Inspector's Report ABP-308396-20

Strategic Housing Development

415 no. residential units (254 no. houses and 161 no. apartments), childcare facility and associated site works

Townland of Readsland, Roestown and Knocks, Dunshaughlin, Co. Meath

OPTION 1: ROAD ACROSS F1 ZONED LAND (PREFERRED)

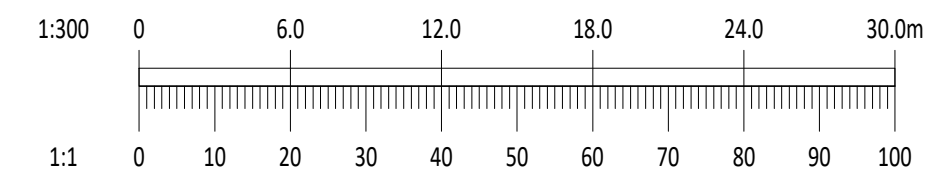
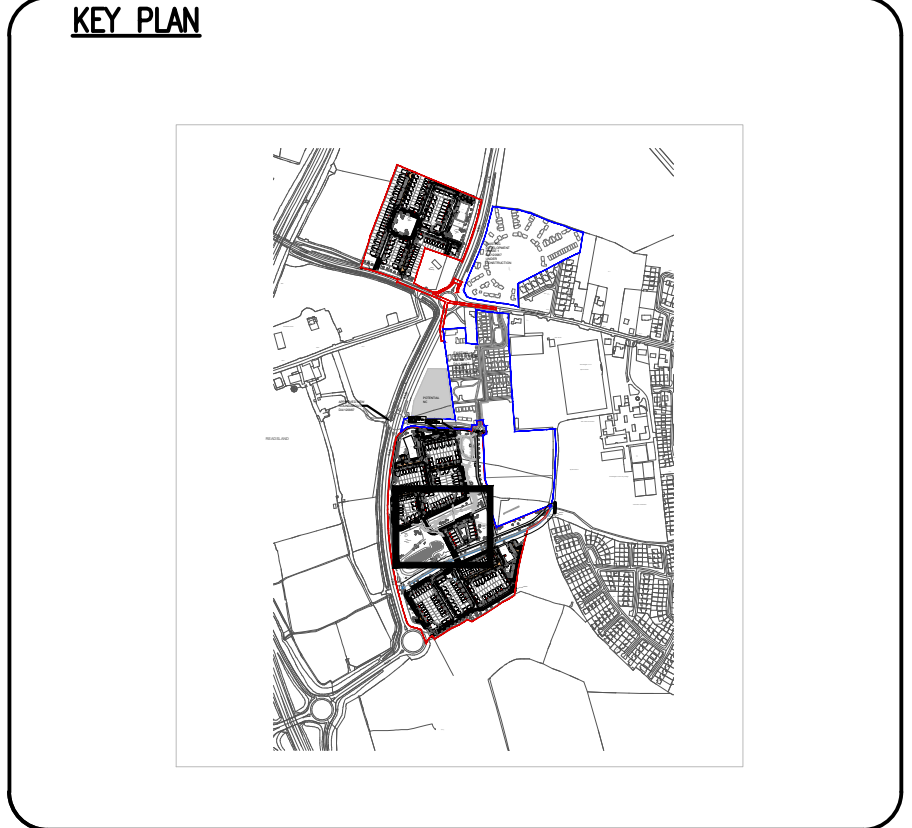
- 6.6.3. The following points are noted in relation to Land Use Zoning:
- The proposed layout indicates a vehicular link between Character Areas 3 and 4 through lands zoned 'F1 Open Space'. The road is not permissible under the F1 objective. However, it has a very limited effect on the use of the lands zoned for public open space and provides broader vehicular permeability in a controlled manner in line with DMURS guidance. It does not impede access to the F1 zoned lands and provides improved pedestrian connectivity through the site and the wider open space lands.

- It is submitted that the road represents a nominal incursion into the F1 lands and should be considered a 'de minimus' matter.
 - The applicant proposes an alternative layout omitting the road between character Areas 3 and 4 should the Board consider that it is not permissible in terms of land use zoning consideration, ref. drawing 12-081A - P171 'Road Options Across F1 Zoned Land'. The EIAR also considers the potential impacts of the revised layout and found that no significant impact would arise from the omission of this road link from the development.
